Office of
Environment
& Heritage

DOC16/587110-1
DA 49/94 MOD 8

Rixs Creek Mine - Modification 8 (DA 49/94)

ATTACHMENT A: OEH REVIEW OF THE ENVIRONMENTAL ASSESSMENT FOR RIXS CREEK MINE MODIFICATION 8

Figure 3: Location of proposed stockpiling areas

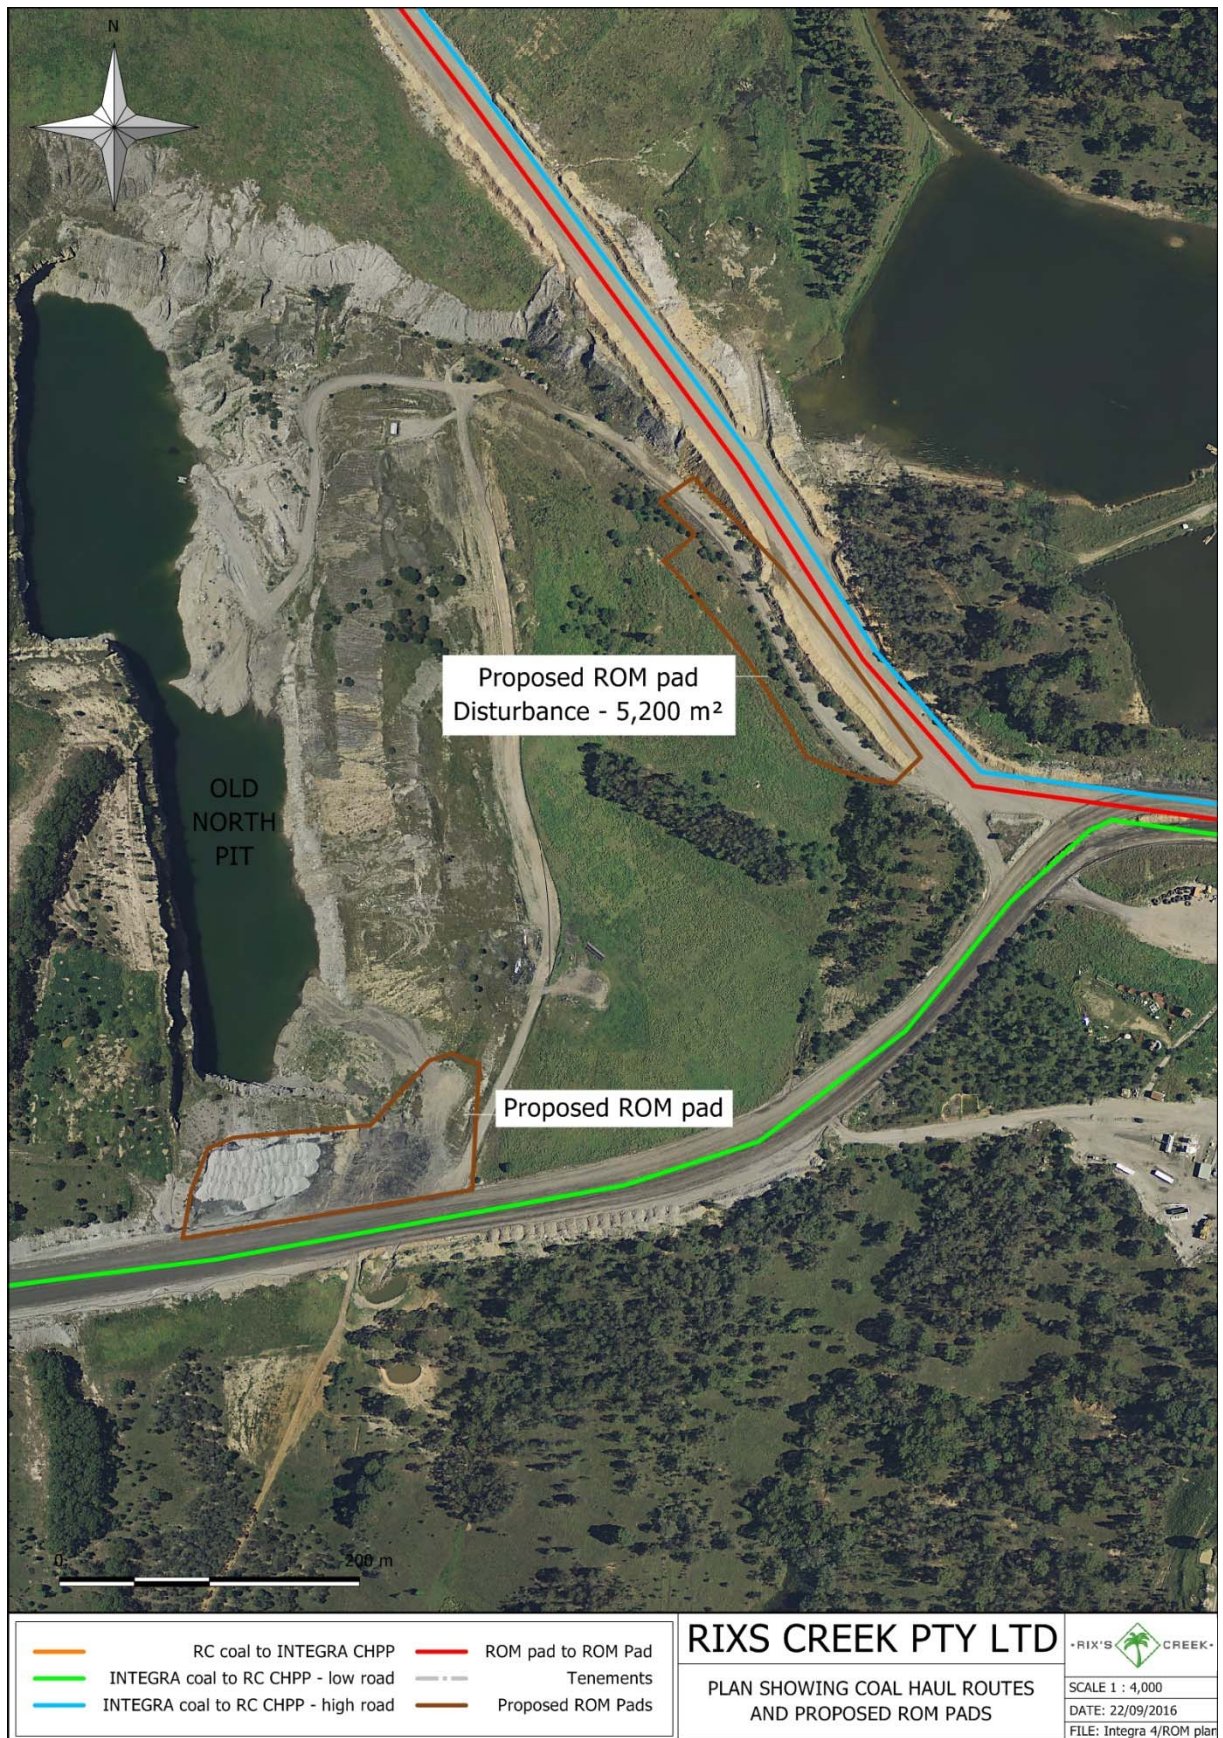
The two Run-of-Mine (ROM) coal pads proposed for this project have a total area of less than one hectare and occur on a post-mined landscape. The southern ROM pad occurs on recently emplaced mine waste. The other occurs on mine waste that was rehabilitated in 1992 and sown with a mix of exotic species, including the Western Australian Golden Wattle (*Acacia saligna*).

The site assessment was conducted in Spring 2016 during which the main species on the site were recorded. No fauna survey appears to have been conducted. The assessment was not done in accordance with the Framework for Biodiversity Assessment (OEH, 2014a) which is the standard assessment for measuring biodiversity impacts under the current 'NSW Biodiversity Offsets Policy for Major Projects' (OEH, 2014b). OEH acknowledges that the Department of Planning and Environment applies discretion when considering the application of this policy for modifications to existing projects, particularly one like this with its original consent that predates the start of biodiversity offsetting policies in this state, and in the scale and nature of the vegetation it will impact.

OEH notes that the proponent is committing to rehabilitate the new stockpile areas once the second coal handling and processing plant is up and running and these ROM pads are no longer needed. They are intended to be rehabilitated with pasture species of the standards seed mix used on the rest of the mine site. However, public expectations post-mine rehabilitation of mine in the Hunter Valley have changed since 1992 with greater consideration of biodiversity values given of new plantings, therefore OEH suggests that if this project is approved that the land is rehabilitated using the tree species mix rather than the pasture mix to return biodiversity values to the site as per the 'Rix's Creek Mine – Rehabilitation Strategy' (AECOM, 2015).

1. That at least half of the area of the new Run-of-Mine coal pads are rehabilitated with the 'trees over grass' mix from the 'Rix's Creek Mine Rehabilitation Strategy' (AECOM, 2015; or later version) within six months of the recommissioning of the Rixs Creek North coal handling and processing plant.
